CITY OF PORTLAND BUILDING PERMIT

Job ID: 2012-03-3559-CH OF USE

Application Number: 2012-421 **Application Date:** 1/31/2012 12:00:00
CBL: 130-G-007 AM
Project Name: Jabbar's Auto Sales
Address: 710 Forest Avenue

710 Forest Ave. – 130-G-007

L2.0

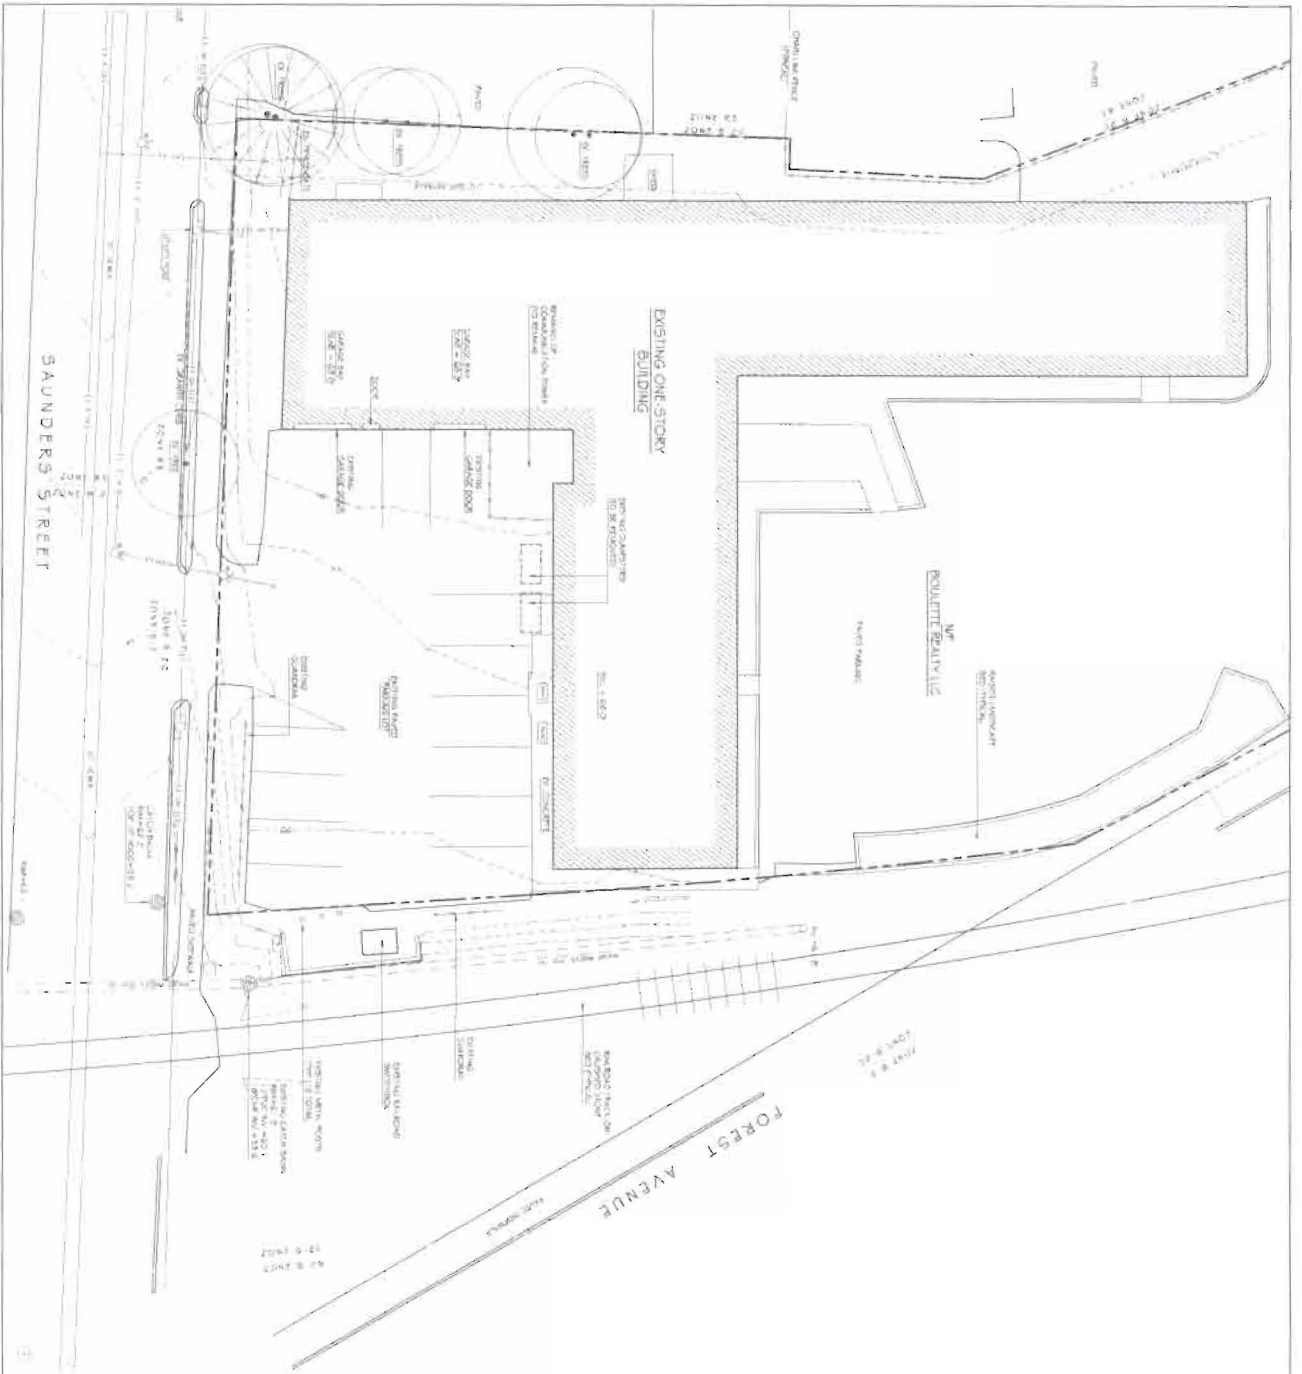
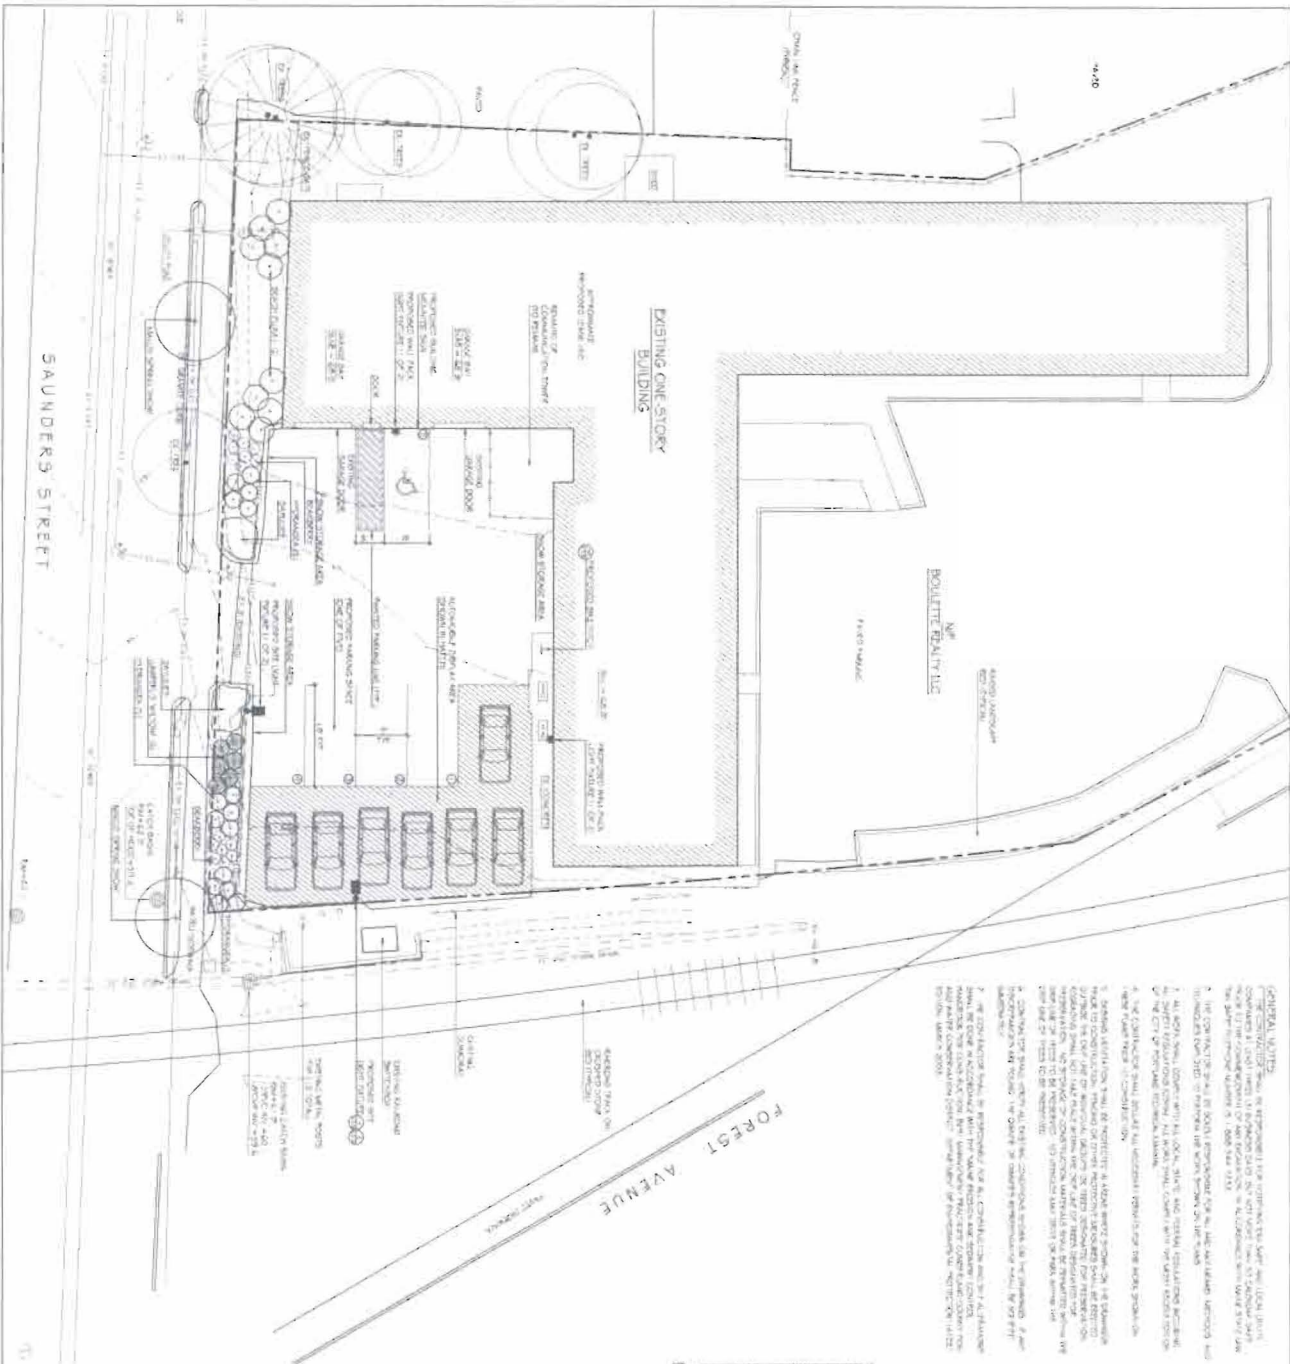
Section 14-339 requires a continuous curb guard for cars parked within ten feet of any street line. The plans do show that a curb guard is currently in place. I did not see any detail of that curb guard.

- i. The rear (westernmost) existing curb cut on Saunders Street shall be used for service/maintenance purposes only and shall not be used for the automobile dealership.

- i. That the storage of snow shall not impede sight distance for vehicles exiting the site; and
- ii. That the proposed wall mounted sign is not part of the site plan review and requires a separate sign permit under Division 22 of the City's Ordinance.
